Reference No:	2026/62/91714/E
Site Address:	adj, 7, Quarryfields, Mirfield, WF14 0NT
Description:	Erection of detached dwelling
Recommending Officer:	Elenya Jackson

DECISION – REFUSED

Officer Report

Proposal: Erection of detached dwelling

Proposed Site Plan
1 : 500

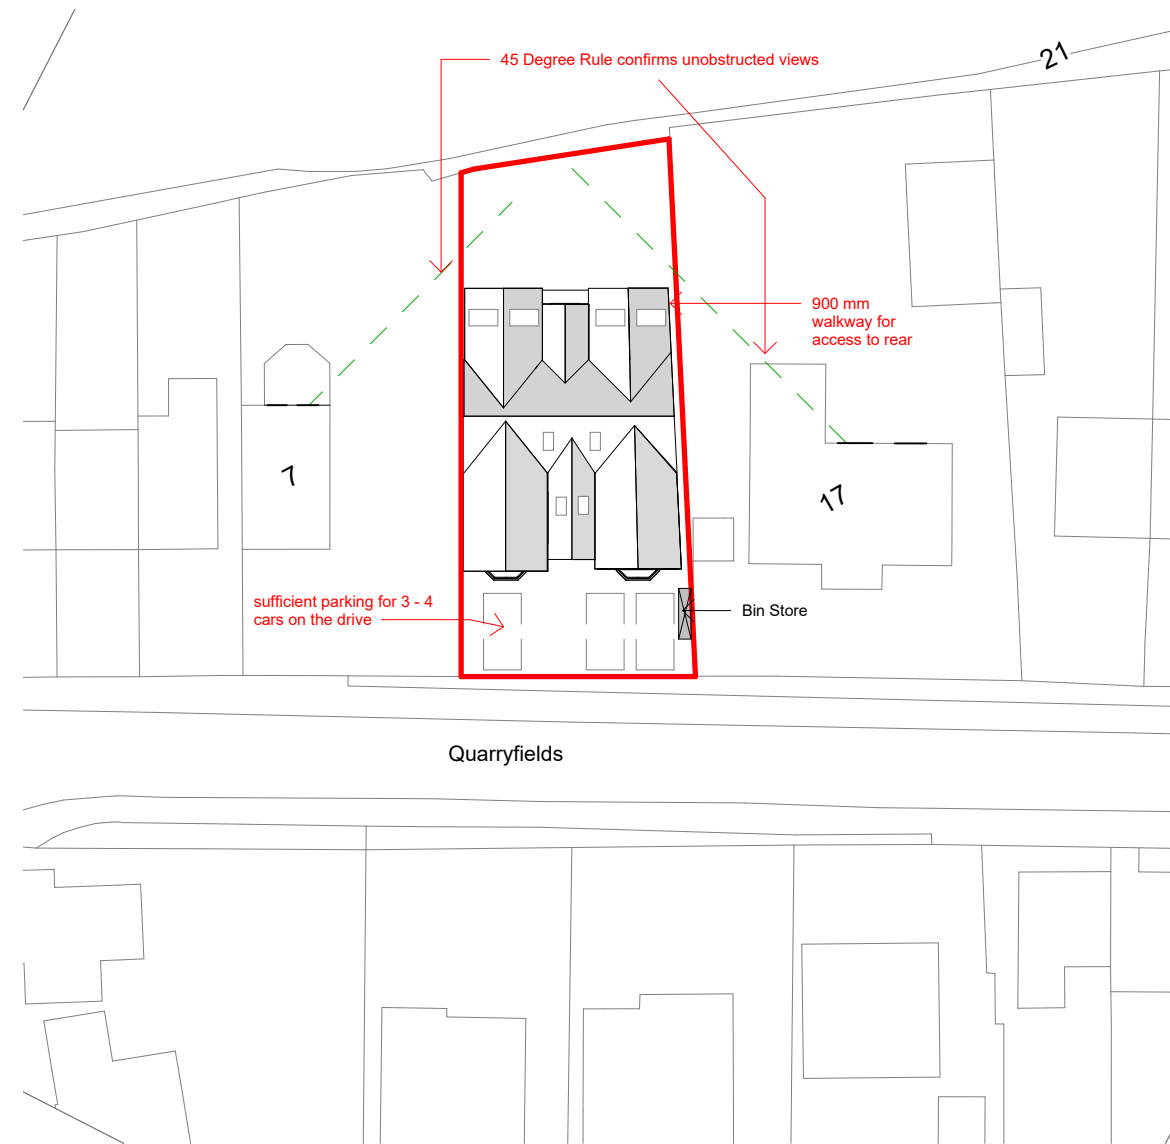
As previously discussed, the street scene follows a reasonably consistent build line, the proposal would be 1.5m forward of no.7 Quarry Fields and 40cm forward of the main dwelling at no.17. It is considered that on balance the proposal would largely accord with the build lines of the street. In terms of footprint and massing, the proposed dwelling would appear overly large within its plot. The built form would extend across the majority of the available plot width with only limited separation to the side boundaries and would leave circa 8m of garden to the rear. It is acknowledged that the surrounding area is not uniform in character and that some spacing would remain between the proposed dwelling and neighbouring properties. However, other dwellings within the street scene are more comfortably accommodated within their plots, with a clearer sense of space around the built form.

17 Quarry Fields: adjoins the application site to the east and would be located 4.7m away from the proposed development.

Overshadowing/loss of light/overbearing: The proposal would be located 8m away from the side of no.7 and located to the east. As the driveway of no.7 is located between the dwellings and the proposal would be orientated to the east, there would be no significant issues raised regarding overshadowing/loss of light/overbearing.

Officers note that bin presentation points haven't been provided on the plan. Therefore, a condition is recommended relating to the submission of waste collection points to be agreed with the LPA.

Proposed Elevations

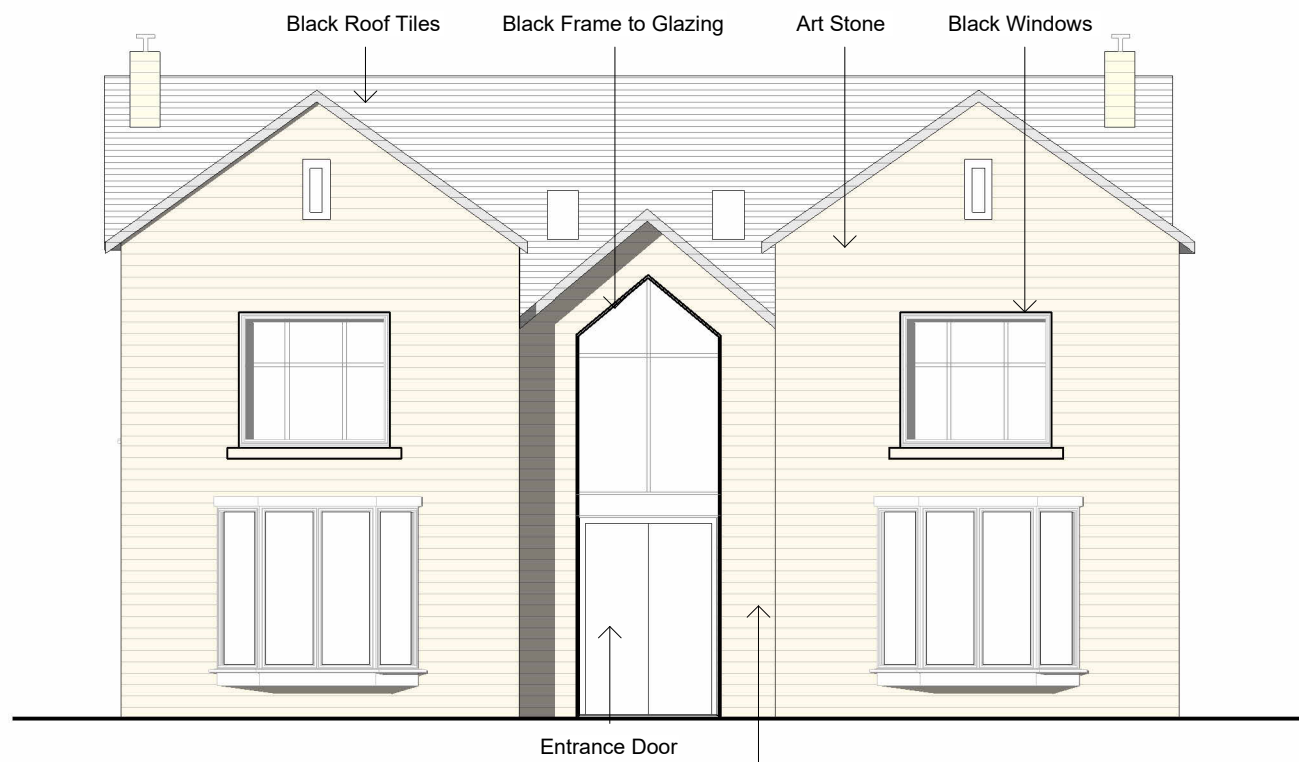
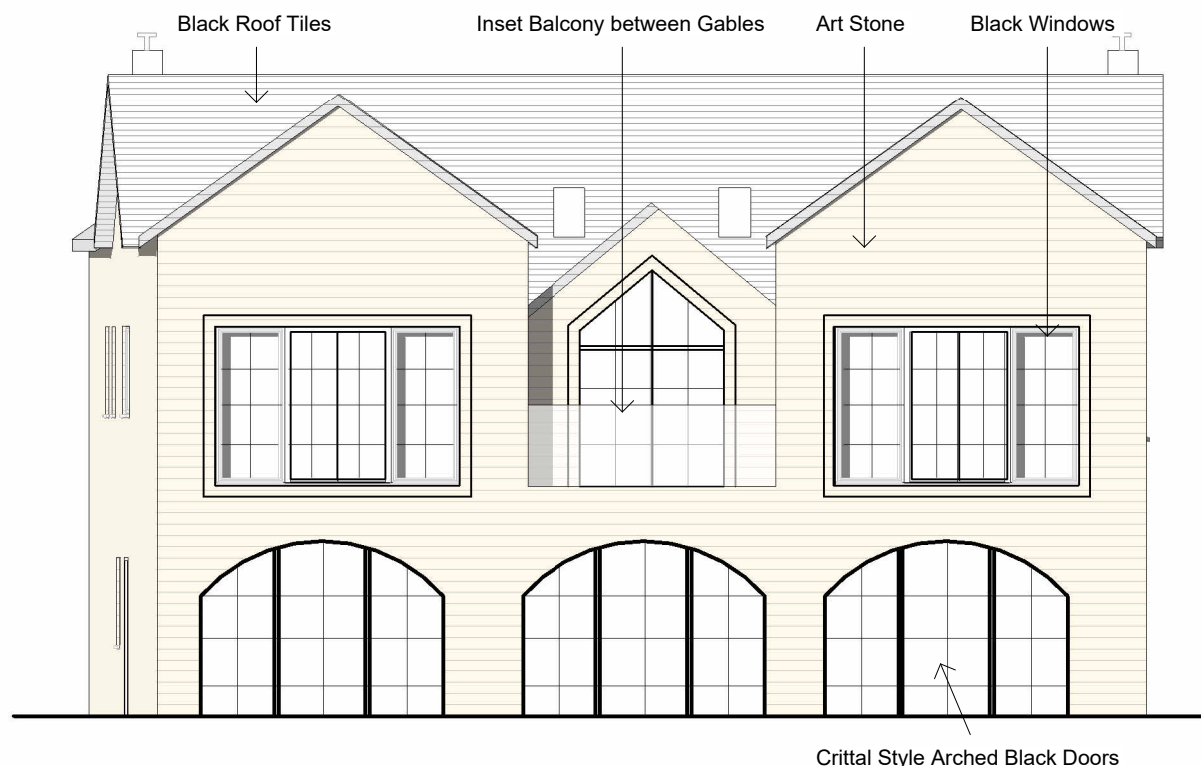
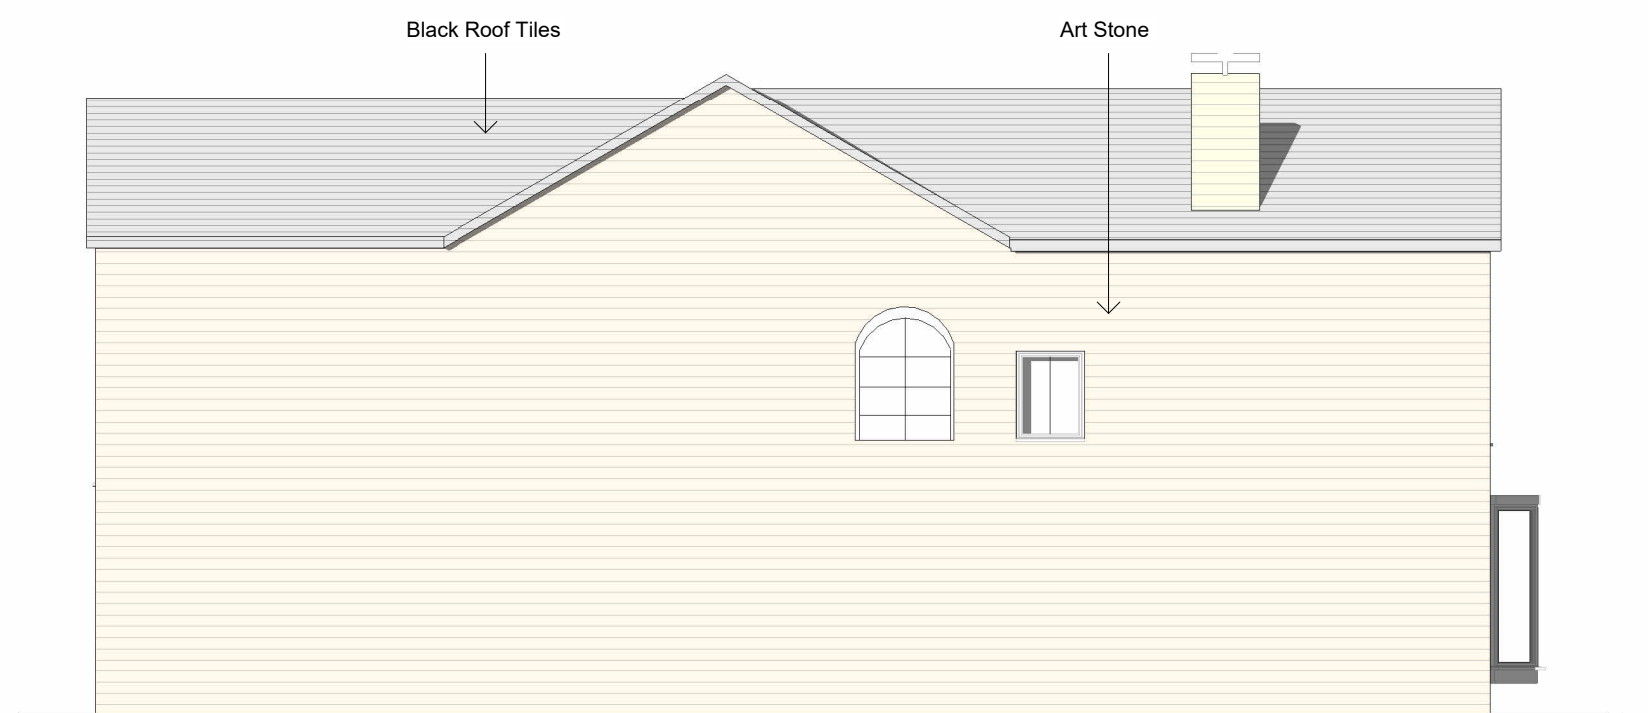
The scale of the footprint is compounded by the two-storey height and substantial roof form. Although the elevations incorporate projecting and recessed elements intended to provide articulation, these would not sufficiently reduce the overall perceived mass of the building. In particular, the broad principal elevation, prominent outer gables and central entrance feature would combine to give the dwelling a wide, bulky and visually dominant appearance within what is a relatively constrained plot.

The proposal would therefore read less as a dwelling comfortably accommodated within its site and more as a building whose dimensions maximise the available developable footprint. The limited visual relief to the sides would further accentuate its width and mass when viewed from Quarryfields. While the proposal would represent a contemporary addition and would retain separation from neighbouring development, these factors would not overcome the cramped relationship between the scale of the building and the plot within which it could sit.

Consequently, the combination of the dwelling's substantial footprint, broad two-storey frontage and roof form would result in an overly dominant and cramped form of development which would fail to respond appropriately to the prevailing character and grain of the surrounding street scene. Therefore, the proposed dwelling would have an unacceptable impact within the existing street scene and against the neighbouring properties in the context of the visual impact.

Overshadowing/loss of light/overbearing: The development would extend approximately 5m beyond the rear elevation of no.17 and would have a maximum height of 8.1m. It is considered that due to the scale bulk and mass of the proposal in close proximity to a shared boundary with no.17, the proposal would result in an overbearing and overshadowing relationship to the immediate amenity space at the rear of no.17 which would be detrimental to the living conditions of the occupiers of this dwelling.

1. By reason of its substantial footprint, scale, bulk and massing, together with the limited separation to the side boundaries, the development would appear cramped and overly dominant within the plot. The development would fail to respond appropriately to the prevailing scale, spacing and grain of development within Quarryfields and would cause harm to the character and appearance of the street scene. The proposal would therefore be contrary to Policy LP24 of the Kirklees Local Plan, Principles 2, 5, 12, 13, 14, and 15 of the Housebuilders Design Guide SPD, and the aims of Chapter 14 of the National Planning Policy Framework.

2. By reason of its scale, bulk and rearward projection, the proposed dwelling would have an overbearing and overshadowing impact upon the rear garden and amenity space of No.17 Quarry fields, resulting in an unacceptable loss of residential amenity. The proposal would therefore be contrary to Policy LP24 of the Kirklees Local Plan, Principle 6 of the Housebuilders Design Guide SPD (2021) and Chapter 14 of the National Planning Policy Framework.
